From: Jane Owen [REDACTED]
Sent: 02 January 2019 19:22
To: Planning
Subject: Planning application a/158/18/pl

A/158/18/PL

Variation of condition1 imposed under A/8/18PL relating to the substitution of approved plan drawings No ADC 962 04 rev A & 13 rev B for drawings No ADC 962 20 &21(ground & first floor plans & roof plans). This application affects the character & appearance of the Angmering Conservation Area,

Land rear of 1 to 6 The Cottrell,Angmering.

Ground Floor Plan @ 1:100

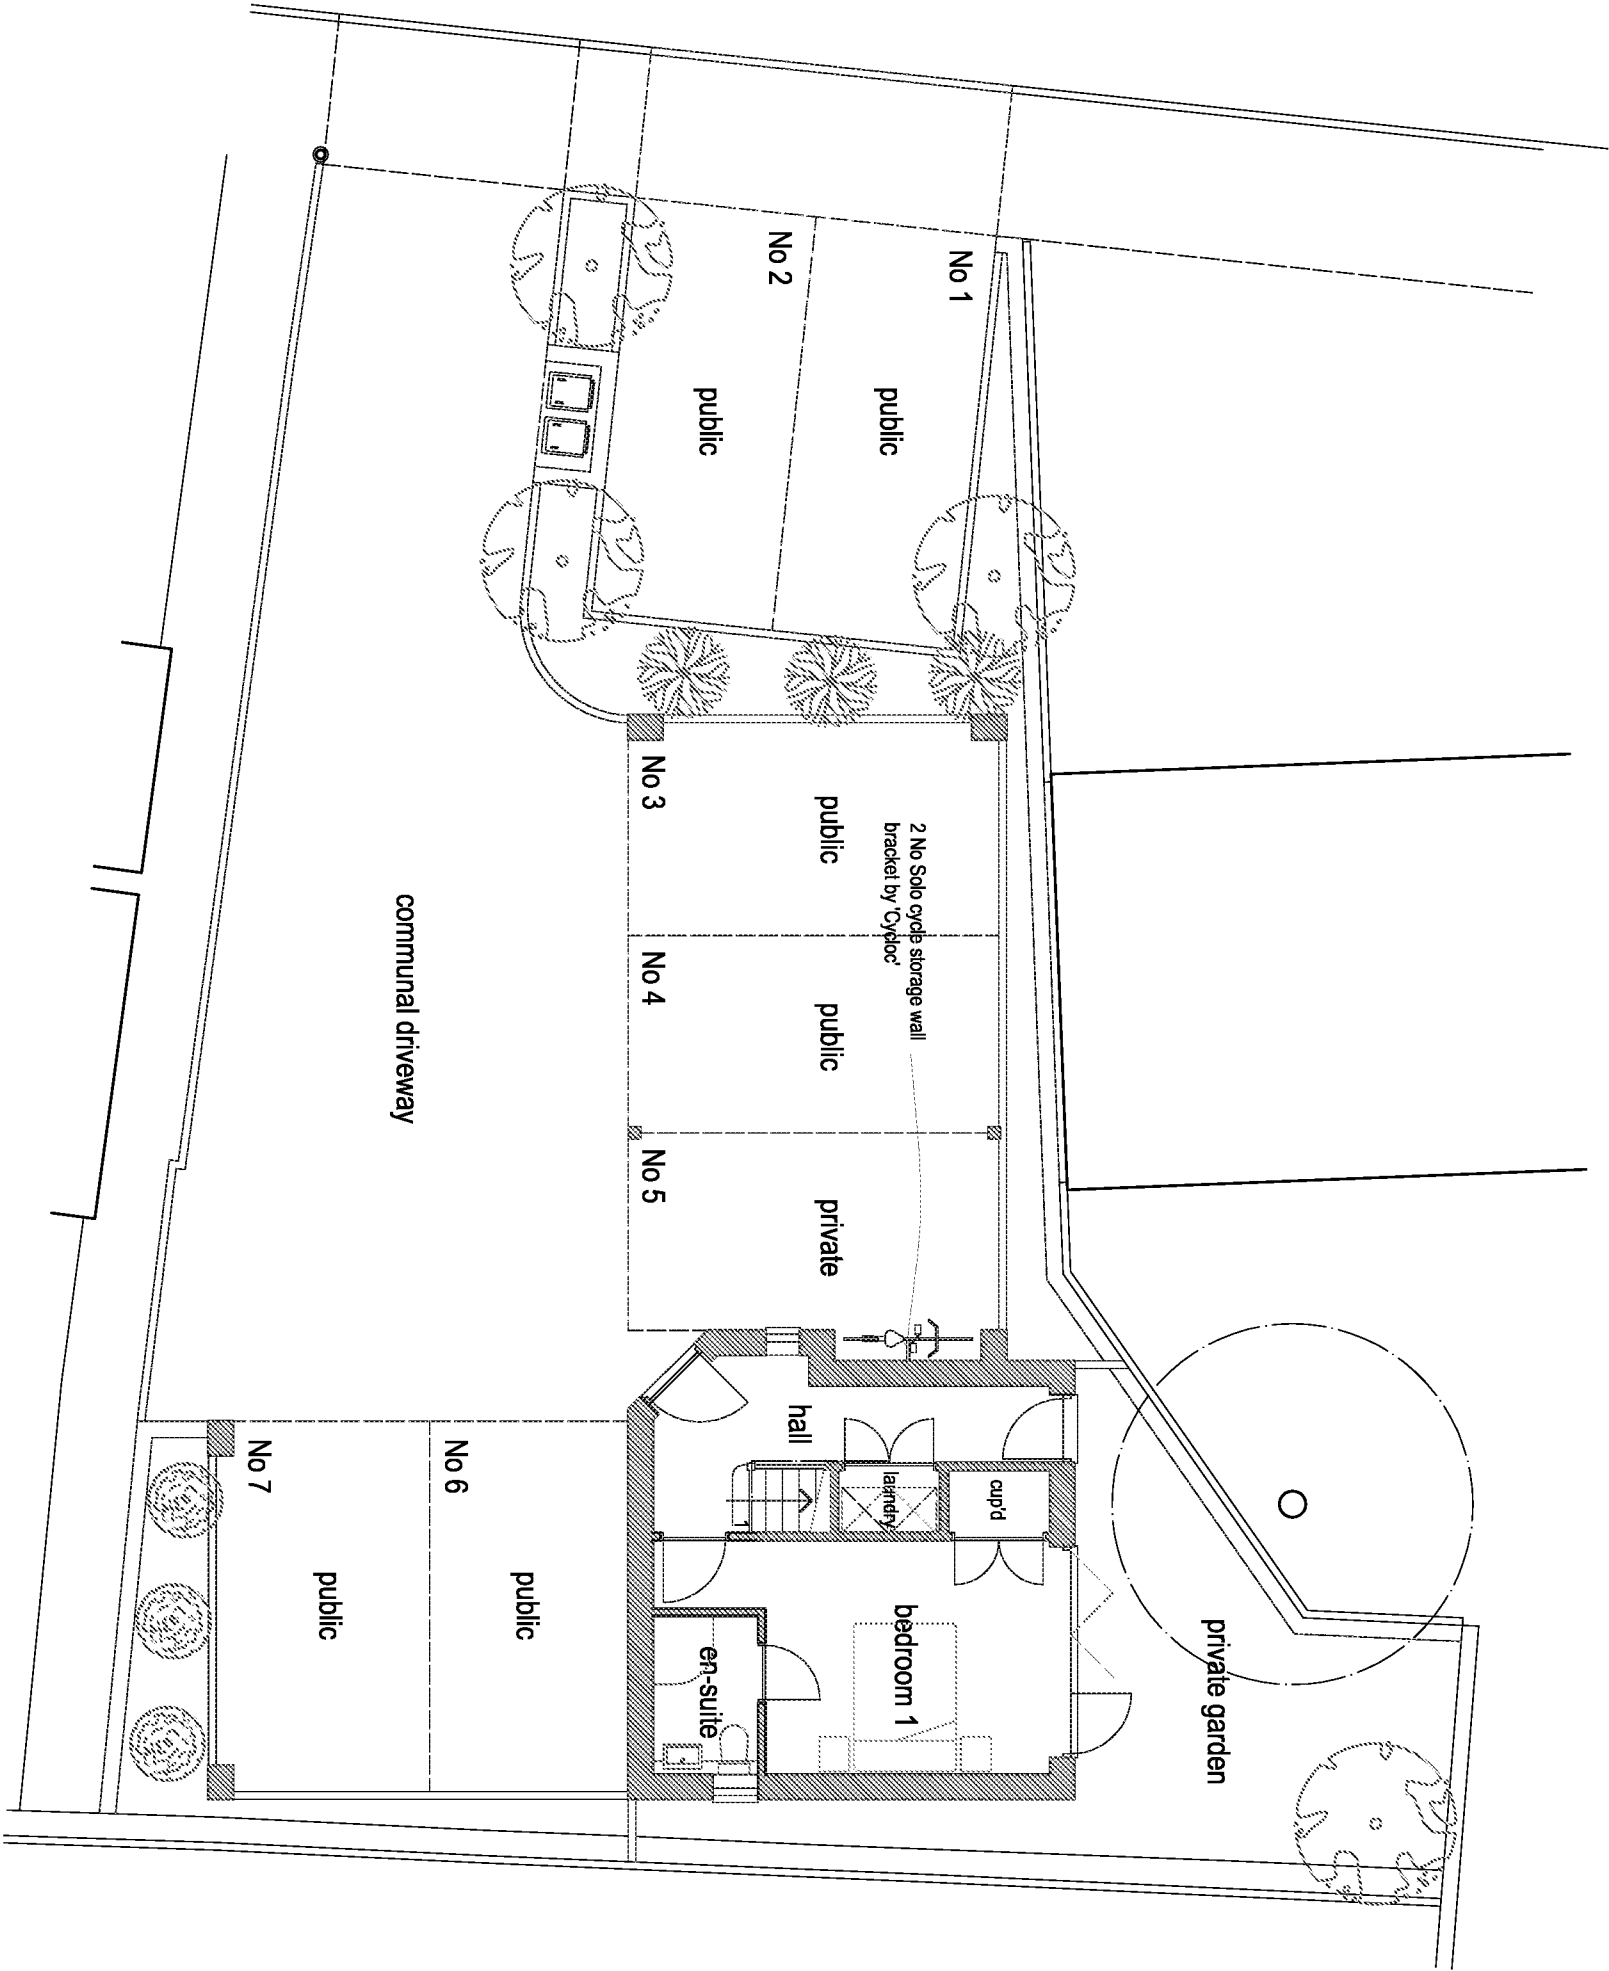
1/ Planning permission was initially granted for a 2 bedroom flat with downstairs garden/store/refuse/cycle room A/105/16/PL. The room was then changed to a kitchen/diner A/173/16/PL, but has actually been built with out planning with a master bedroom with en-suite downstairs, lounge/kitchen diner upstairs.In effect making it a three bedroom property

First Floor Plan @ 1:100

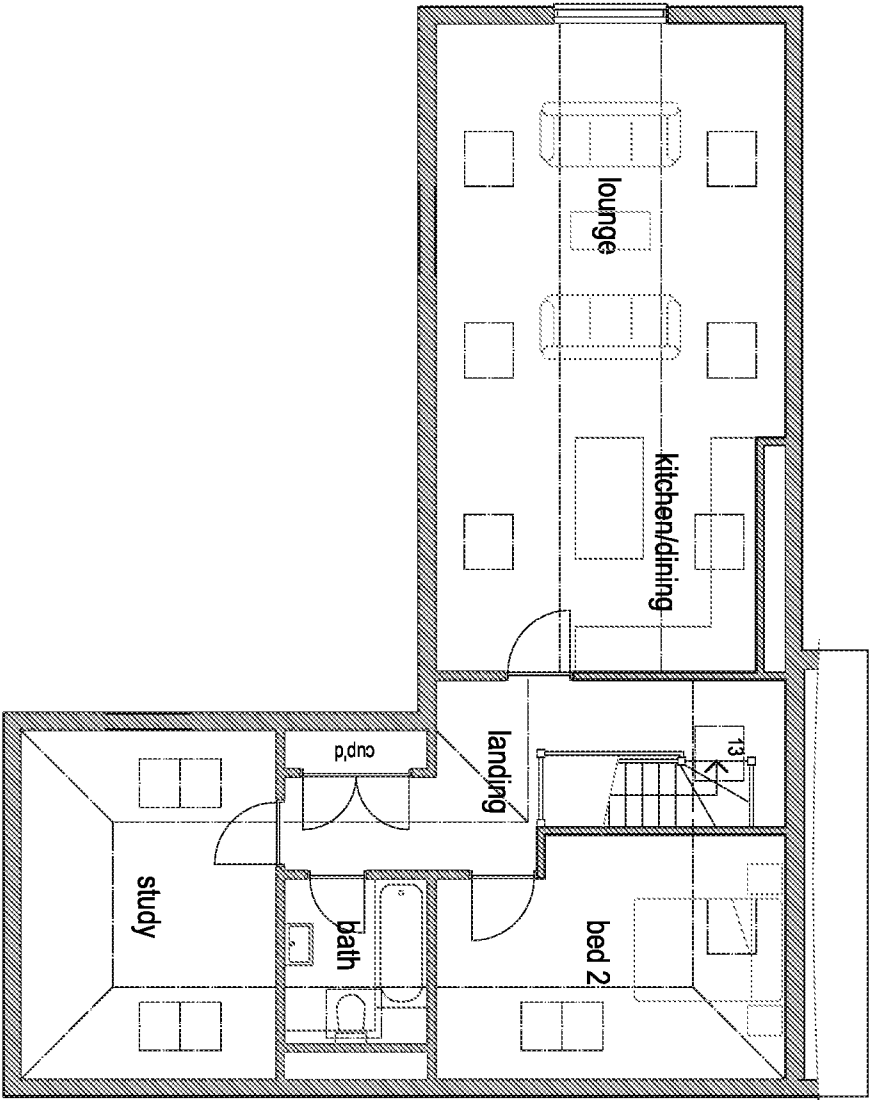
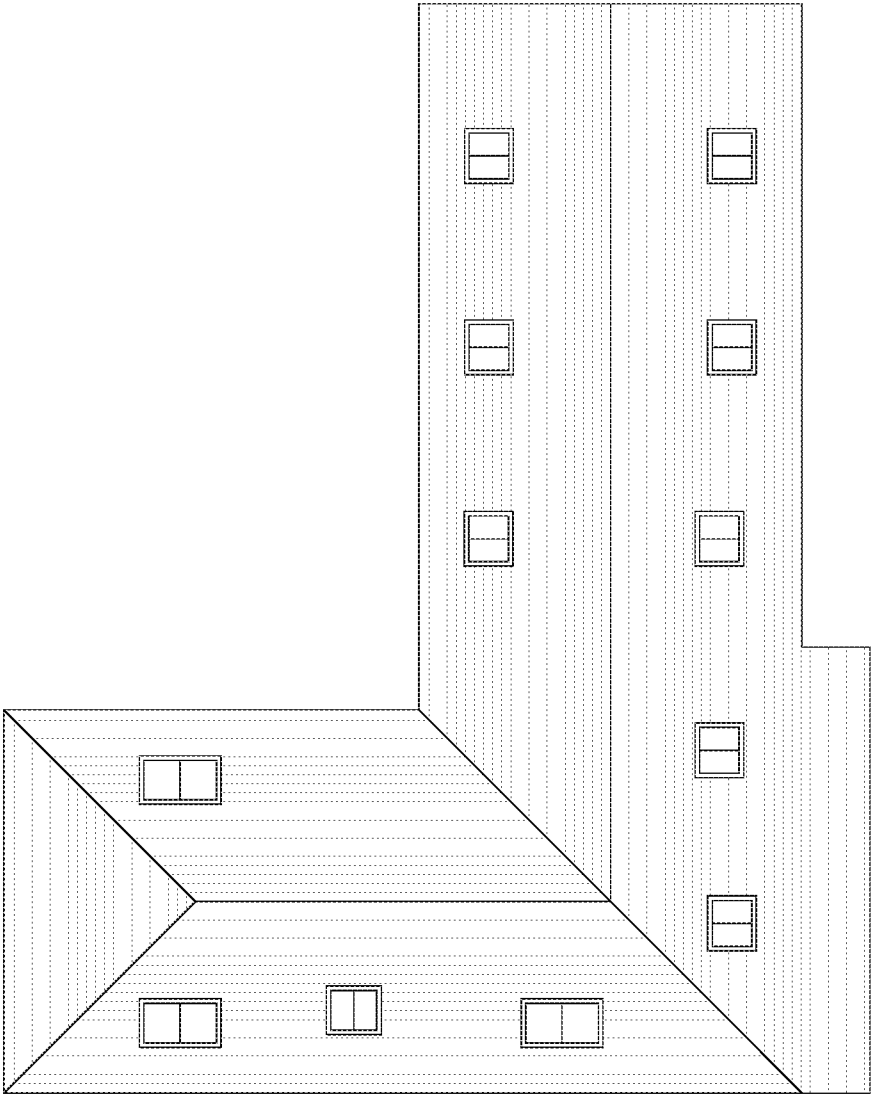
2/ Planning was given for emergency roof lights which have not been installed, showing complete disregard for the planning department and all health and safety requirements. It also shows he never intended on putting the kitchen diner downstairs which would have necessitated the safety windows upstairs.
